DRB CASE ACTION LOG (PREL & FINAL)

DRB Application No.: 07DRB-70194 (P&F)	Project # 1006742
Project Name EAST CENTRAL BUSINESS ADDITION	
Agent: SURVEYS SOUTHWEST LTD	Phone No.: 998-0303

RE: Lots 1 & 10, Block 14, East Central Business Addition/p&f

PLAT OF
 LOTS 1-A & 10-A, BLOCK 14
 EAST CENTRAL BUSINESS ADDITION
 SECTIONS 21 & 28, T. 10 N., R. 4 E., N.M.P.M.
 CITY OF ALBUQUERQUE
 BERNALILLO COUNTY, NEW MEXICO
 AUGUST 2007
 PAGE 2 OF 2

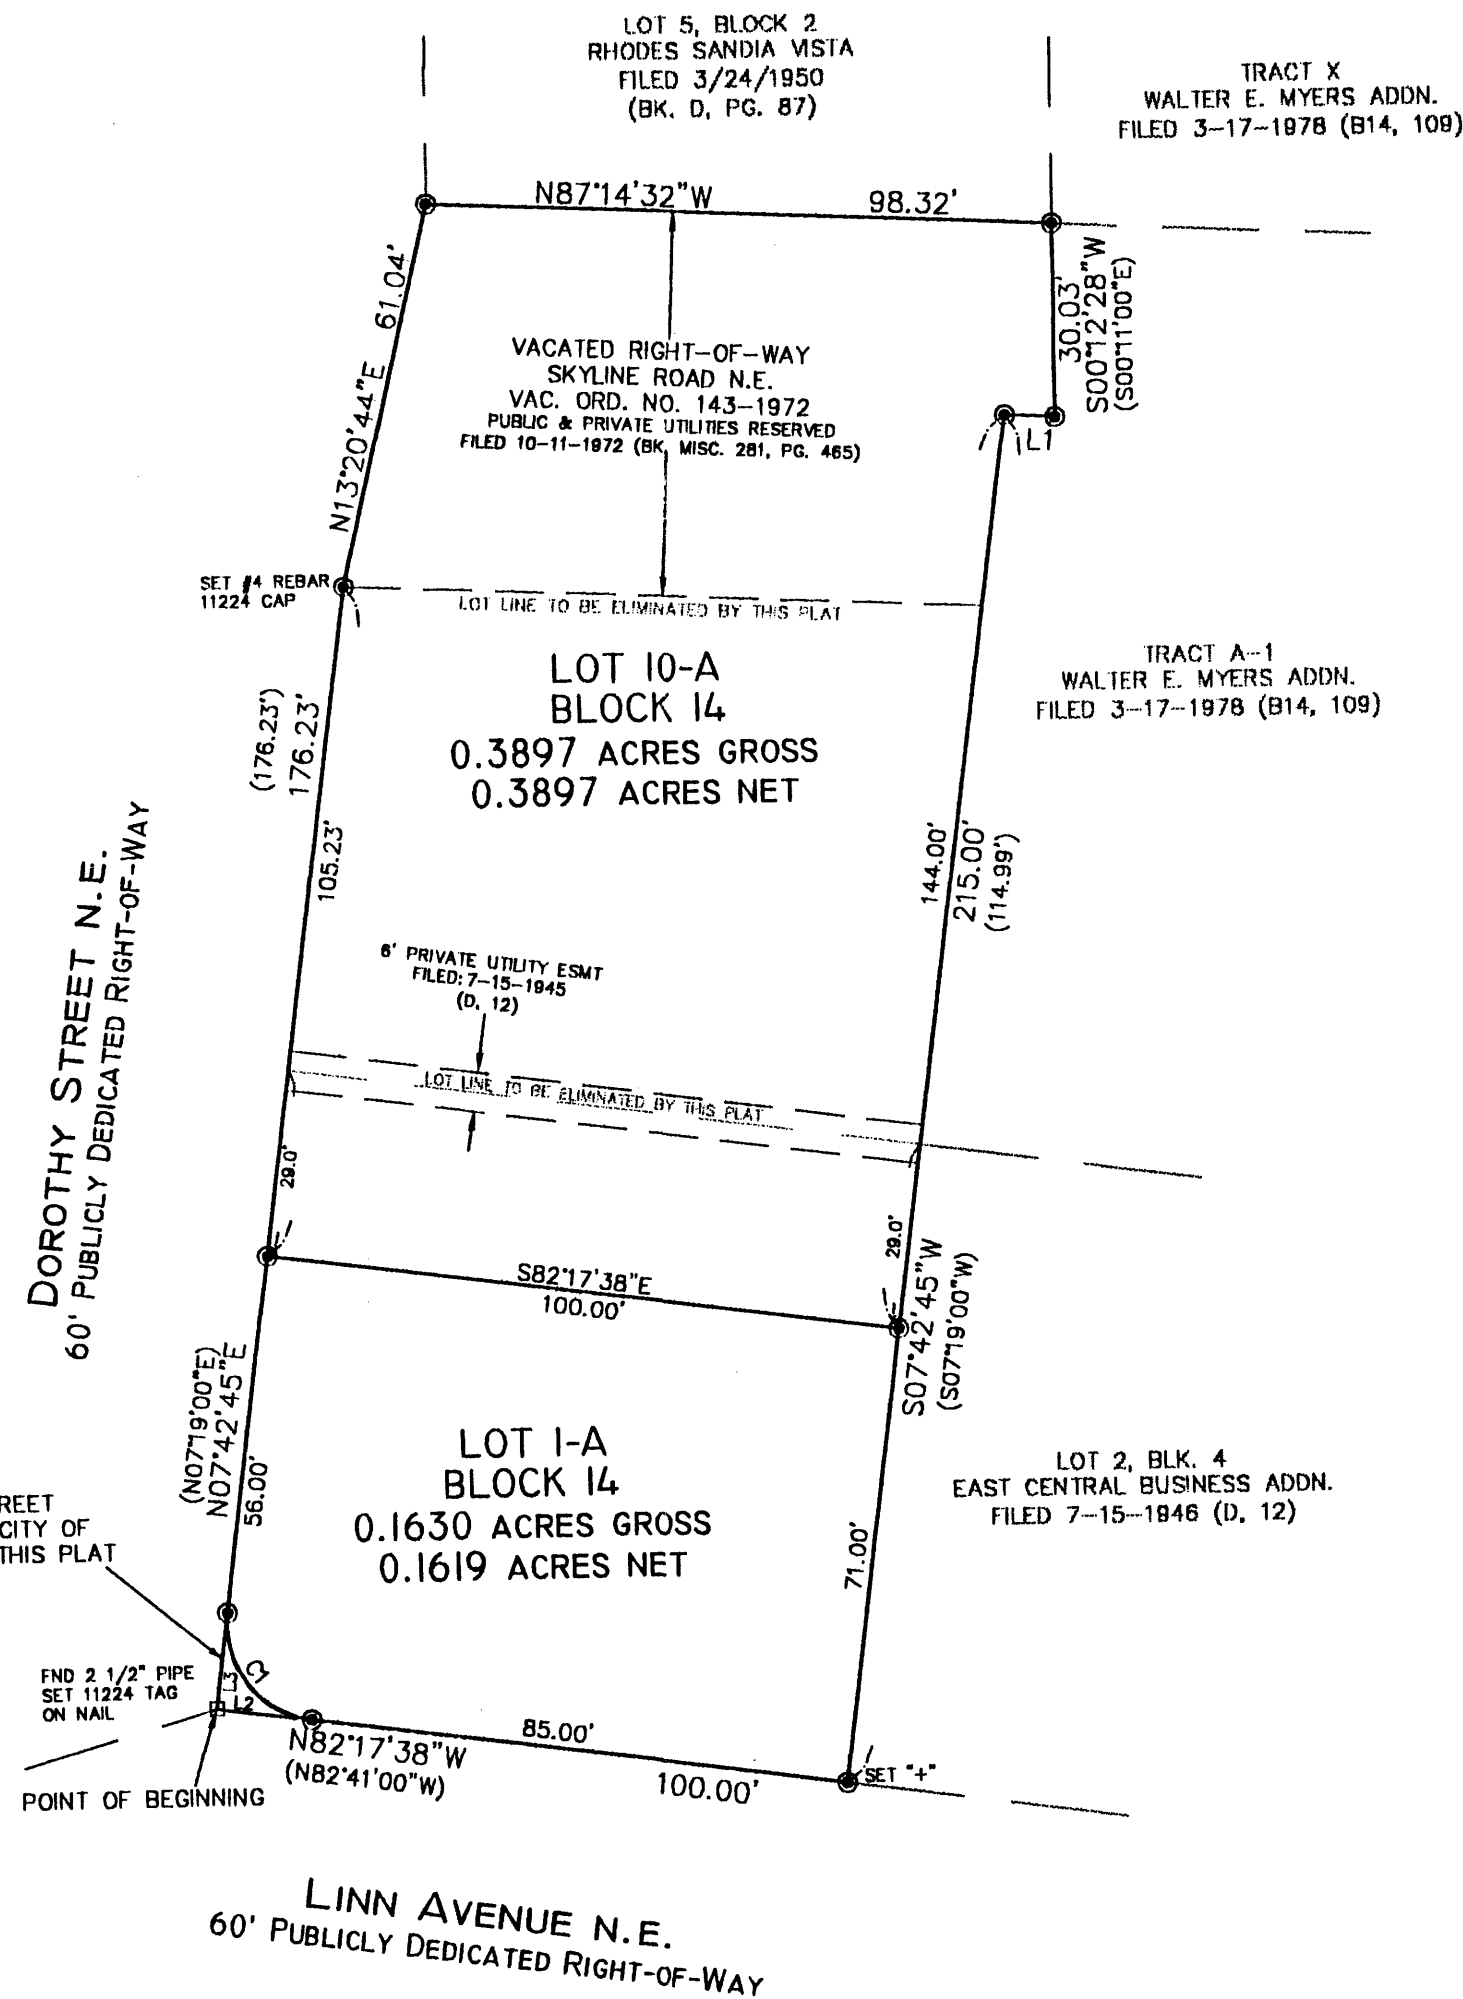
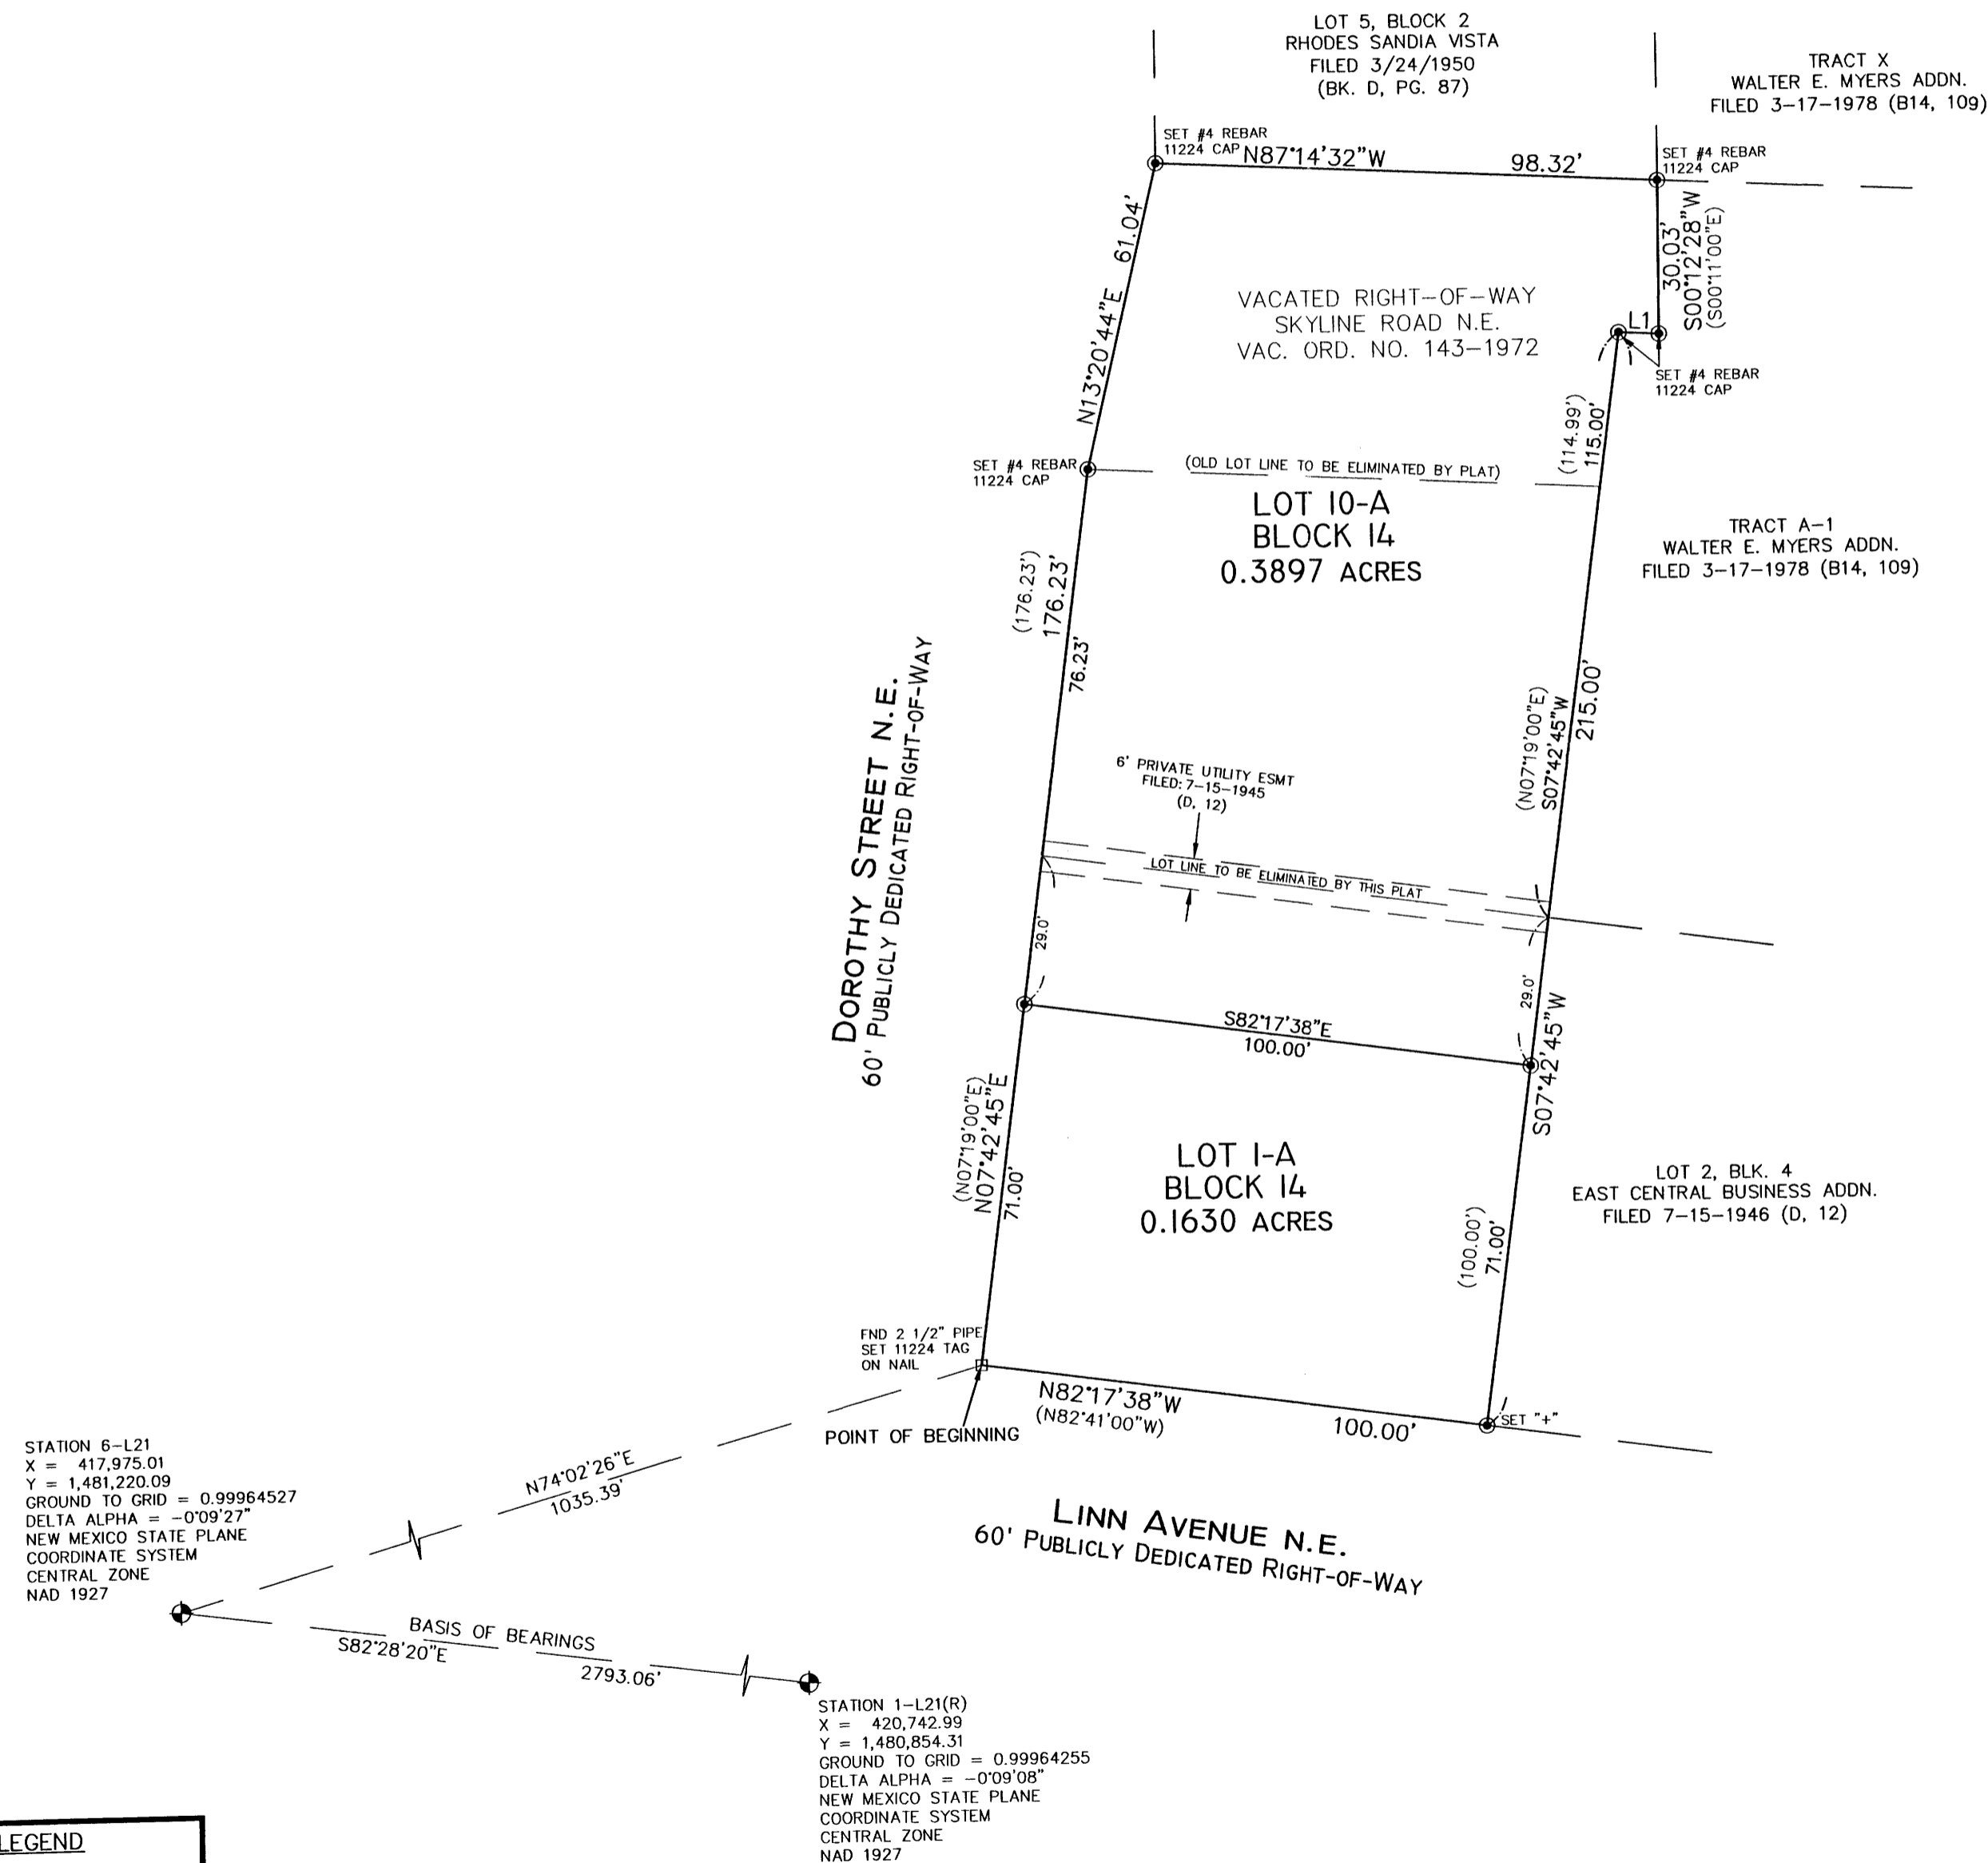
- TRANSPORTATION: 15' radius on Lynn's Property. dk
- _____
- _____
- _____
- _____
- ABCWUA: _____
- _____
- _____
- _____
- CITY ENGINEER / AMAFCA: _____
- _____
- _____
- _____
- PARKS / CIP: _____
- _____
- _____
- _____
- PLANNING (Last to sign): _____
- _____
- _____
- _____

SURVEYS SOUTHWEST LTD agent(s) for JOE OLIVAS request(s) the above action(s) for all or a portion of Lot(s) 1 & 10, Block(s) 14, **EAST CENTRAL BUSINESS ADDITION**, with a portion of vacated Skyline Rd NE, zoned C-2, located on DOROTHY ST NE BETWEEN LINN AVE NE AND MARTHA ST NE containing approximately 0.5527 acre(s). (L-21) **PRELIMINARY AND FINAL PLAT WAS APPROVED WITH FINAL SIGN OFF DELEGATED TO TRANSPORTATION DEVELOPMENT FOR 15-FOOT RADIUS ON LINN AND DOROTHY AND COPY OF THE RECORDED PLAT.**
